I AM WRITING TO YOU REGARDING THE PROPOSED PROPERTY ON LAND NORTH OF 13 HAZEL AVENUE WITHERNSSEA.

PROJECT DETAILS
ERECTION OF A DWELLING
**OUTBUILDING & SITE PLANS
AND LOCATION PLAN**

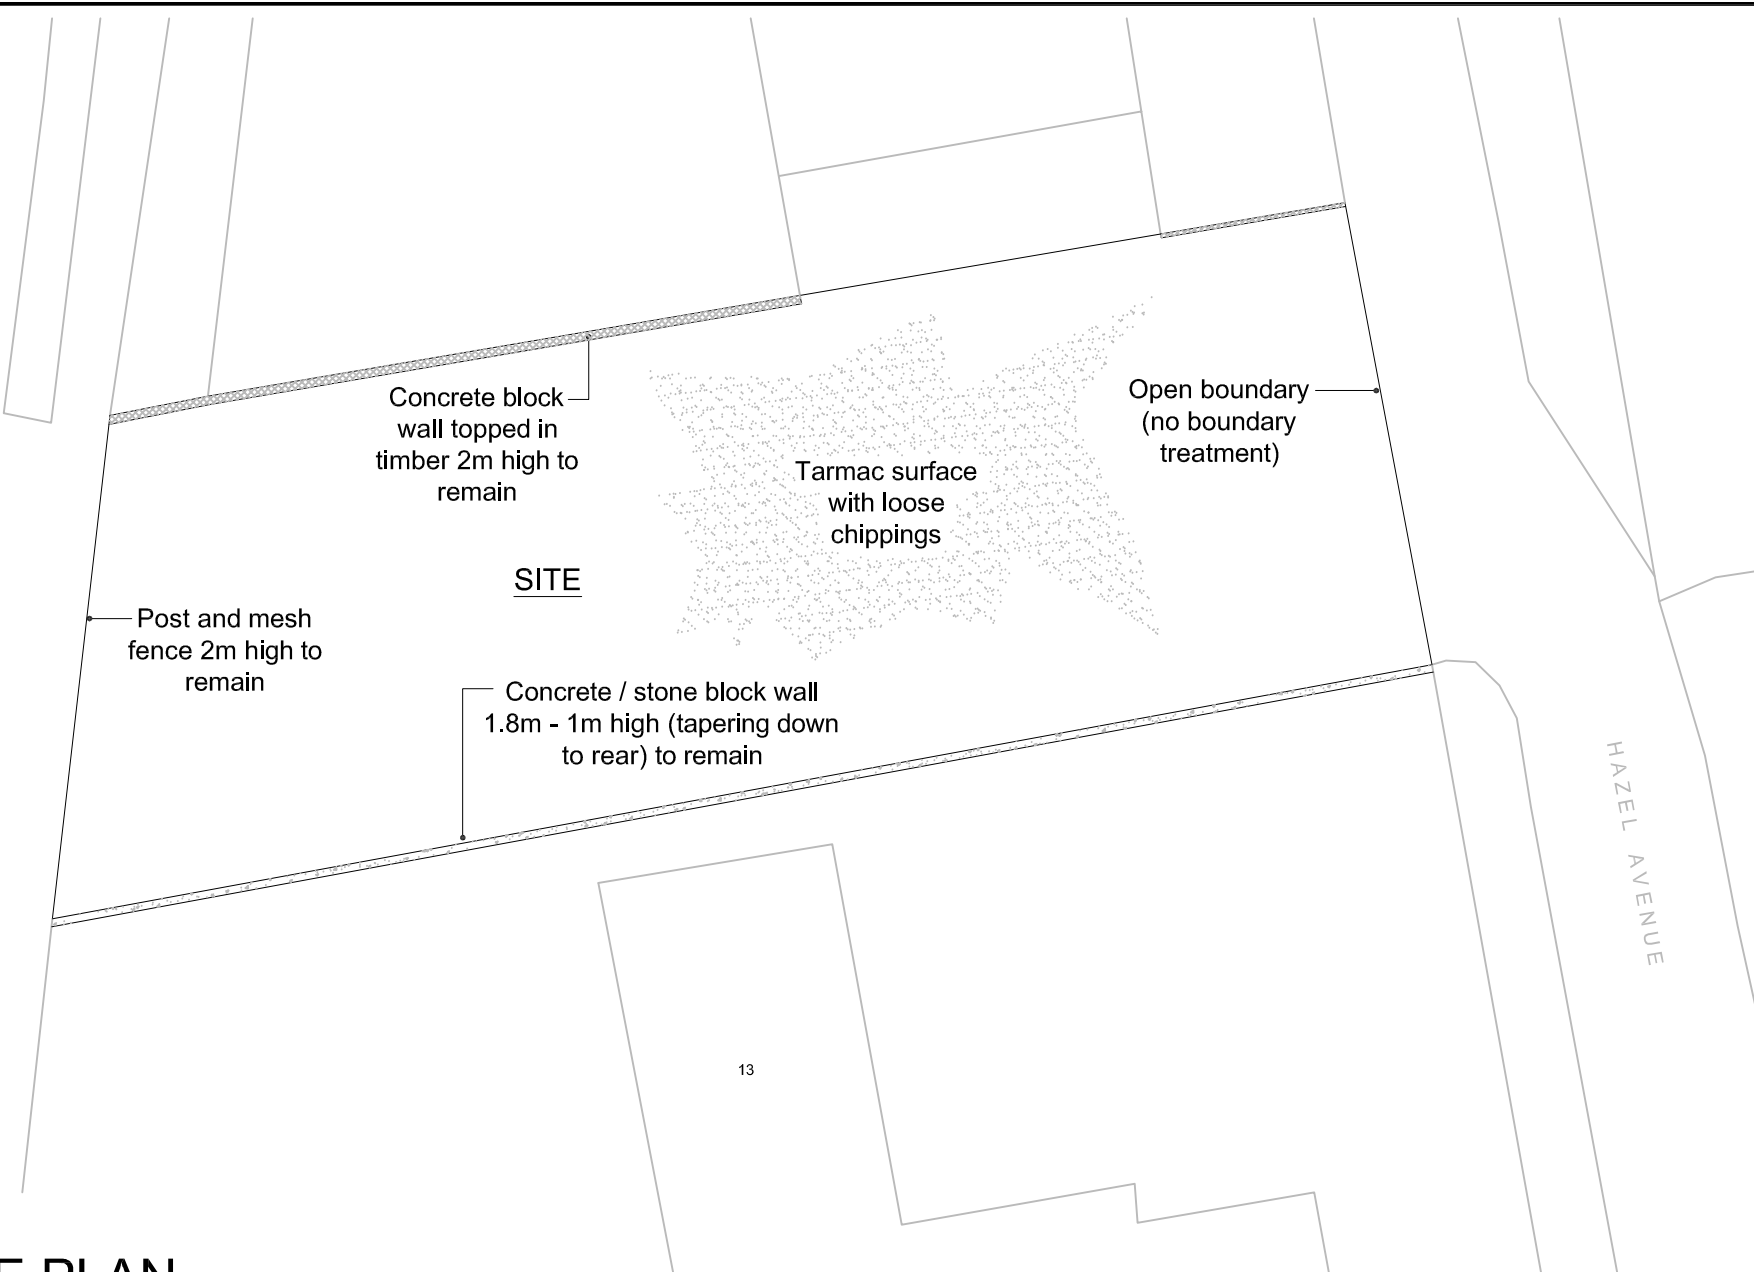
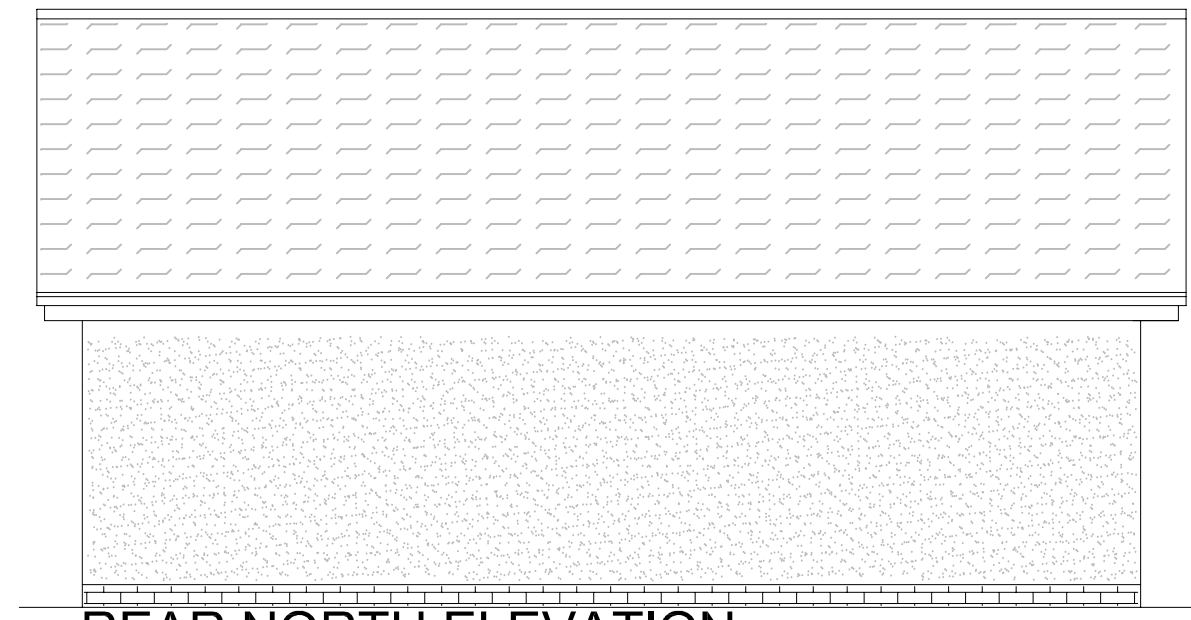
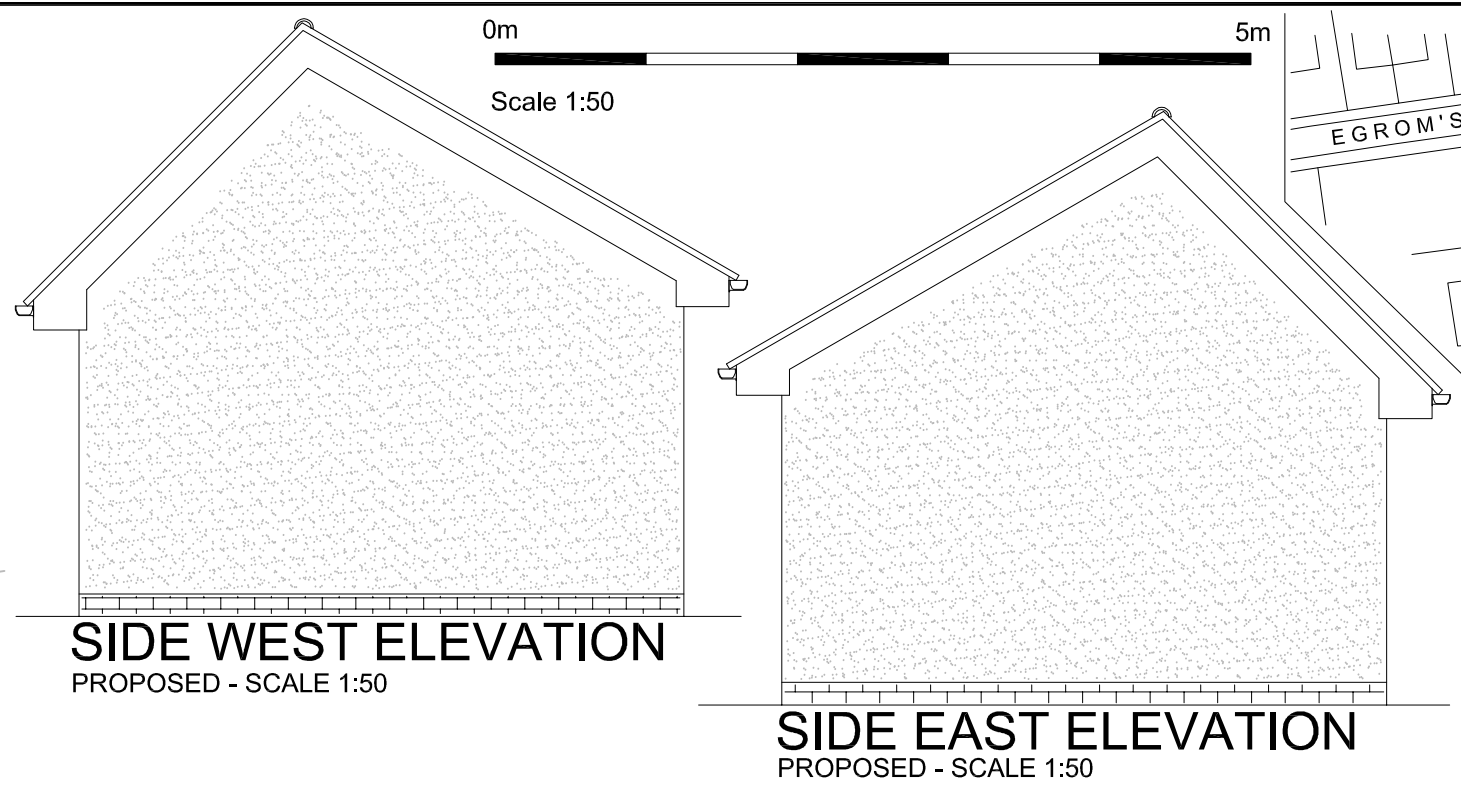
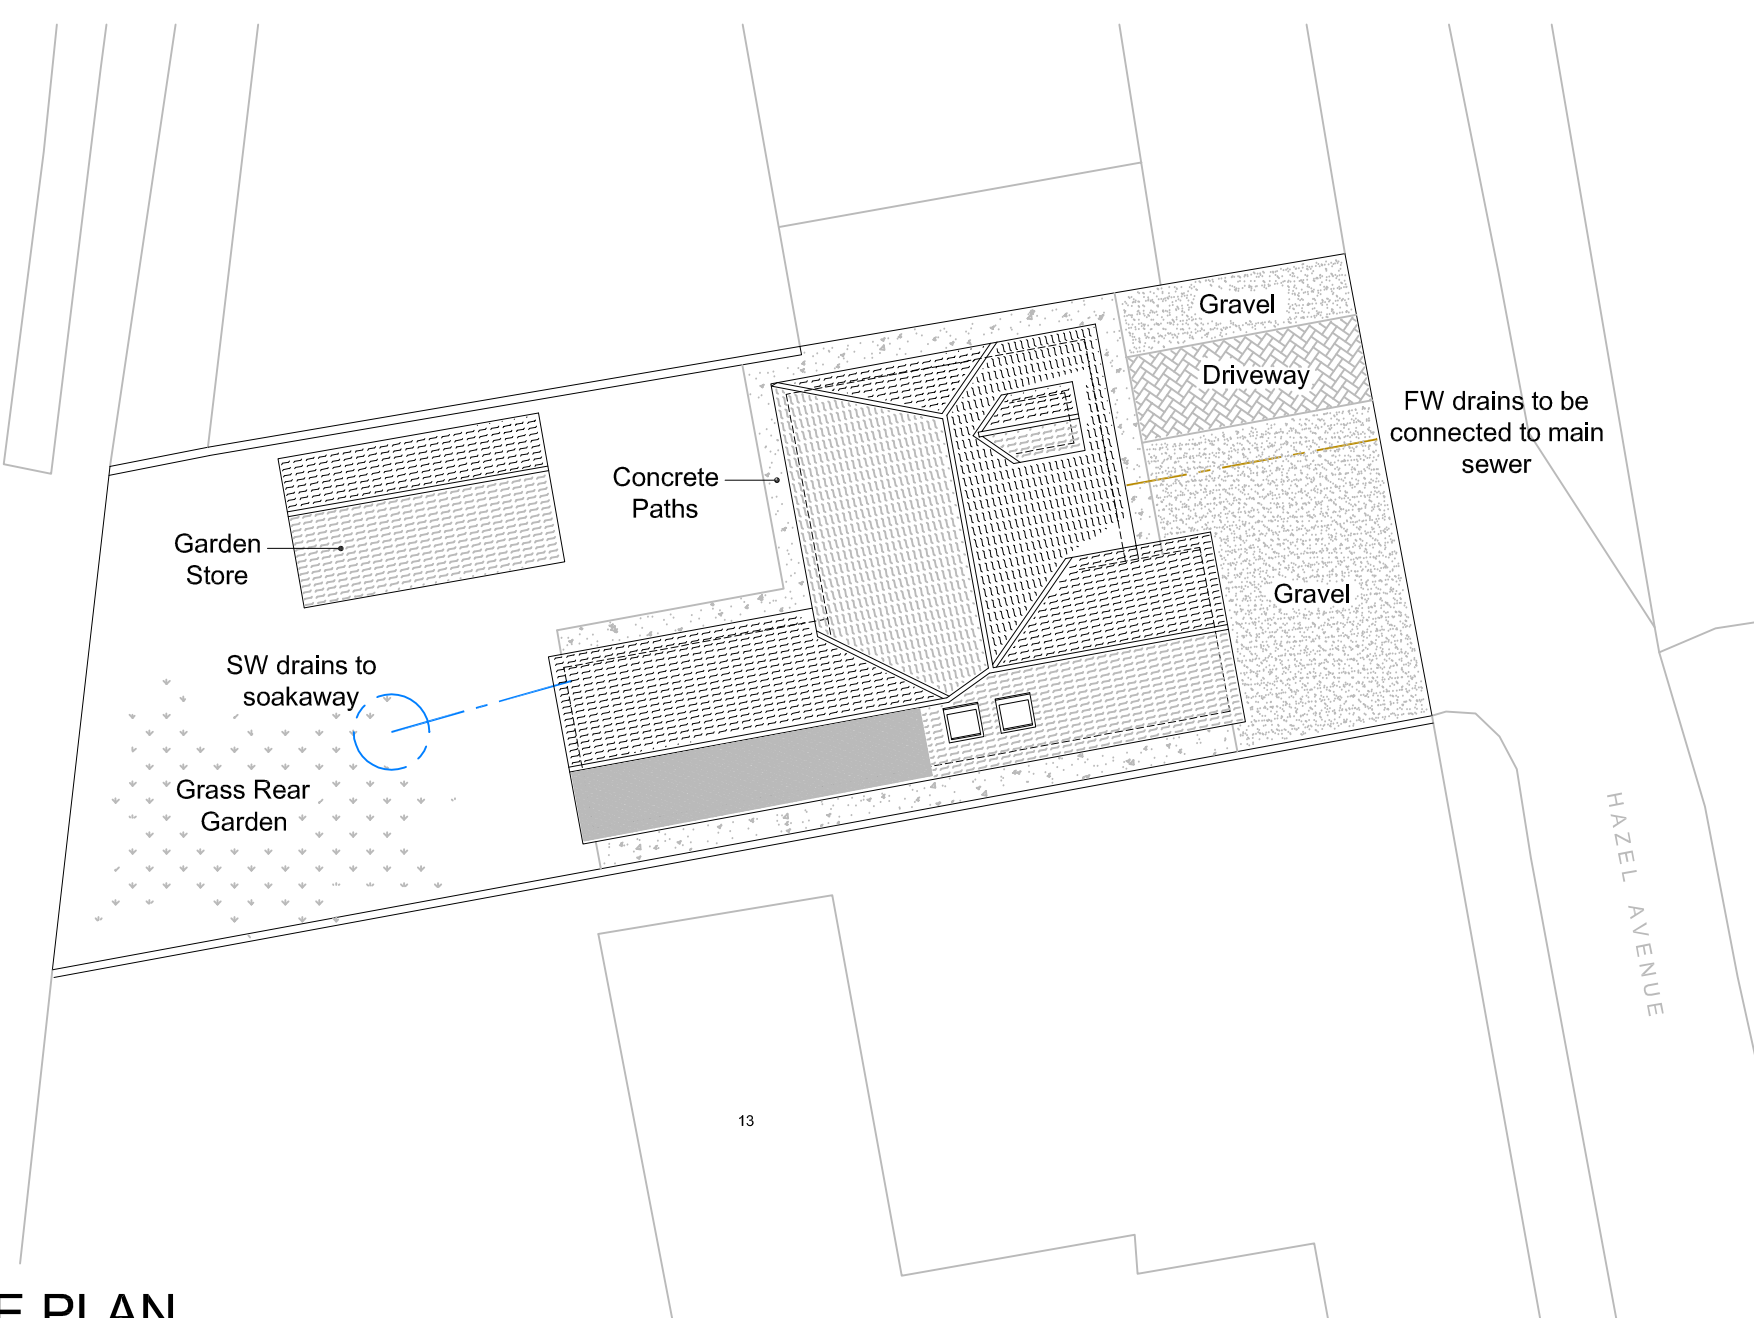
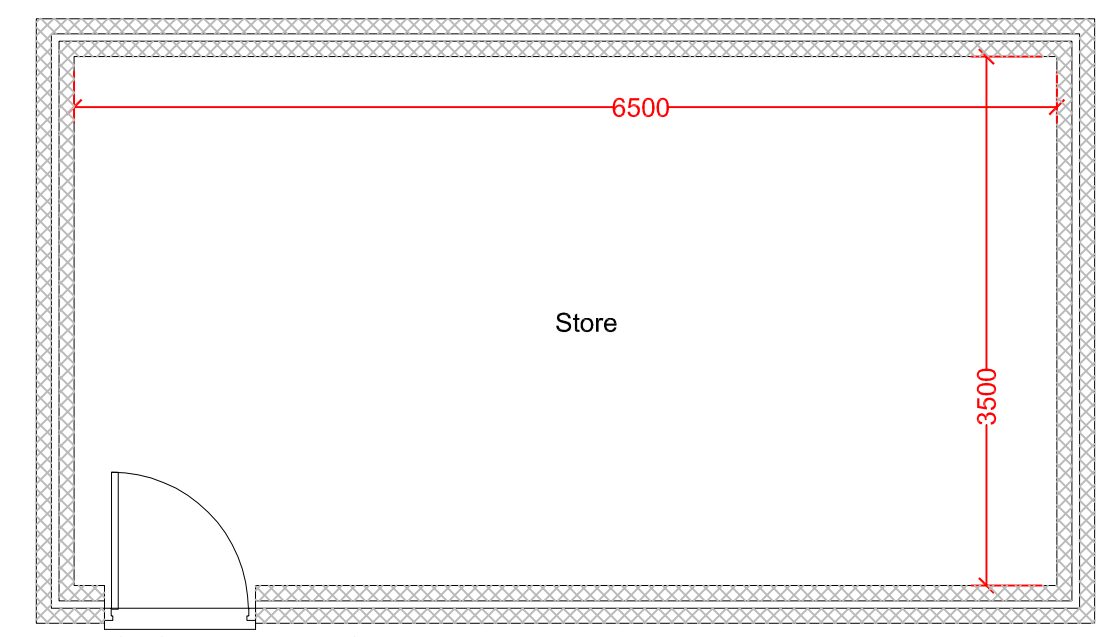
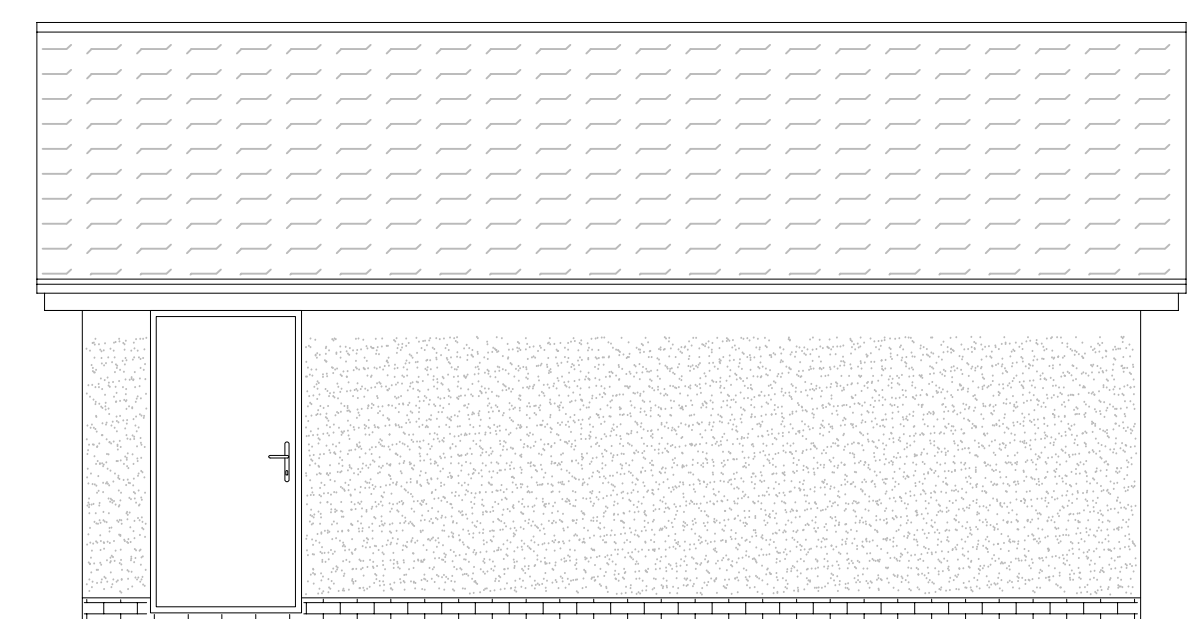
ORIGINALLY THE PROPOSED PROPERTY WAS TO HAVE BEEN A BUNGALOW, BUT IT HAS NOW BEEN CHANGED TO A 4 BEDROOMED HOUSE, WITH A GARDEN 'STORE' IN THE GARDEN WHICH IS TO BE 6.5M²S X 3.5M²S. WHAT EXACTLY IS THIS GOING TO BE 'STORE' !! ITS HUGE, NOT AN ORDINARY GARDEN SHED, THATS FOR SURE!!

THE HEIGHT OF THE PROPOSED PROPERTY IS CERTAINLY GOING TO AFFECT MY NEIGHBOURS AT N⁰S 13 AND 15. NUMBER 13 ARE GOING TO HAVE THEIR PRIVACY COMPROMISED AS THERE ARE 2 BEDROOM WINDOWS OVERLOOKING THEIR FRONT DOOR AND GARDEN AND NUMBER 15 ARE GOING TO LOSE AN AWFUL LOT OF SUNSHINE AT THE FRONT AND BACK GARDEN. THIS HUGE 'GARDEN STORE' IS GOING TO OVER SHADOW THE BOTTOM OF THEIR GARDEN TOO.
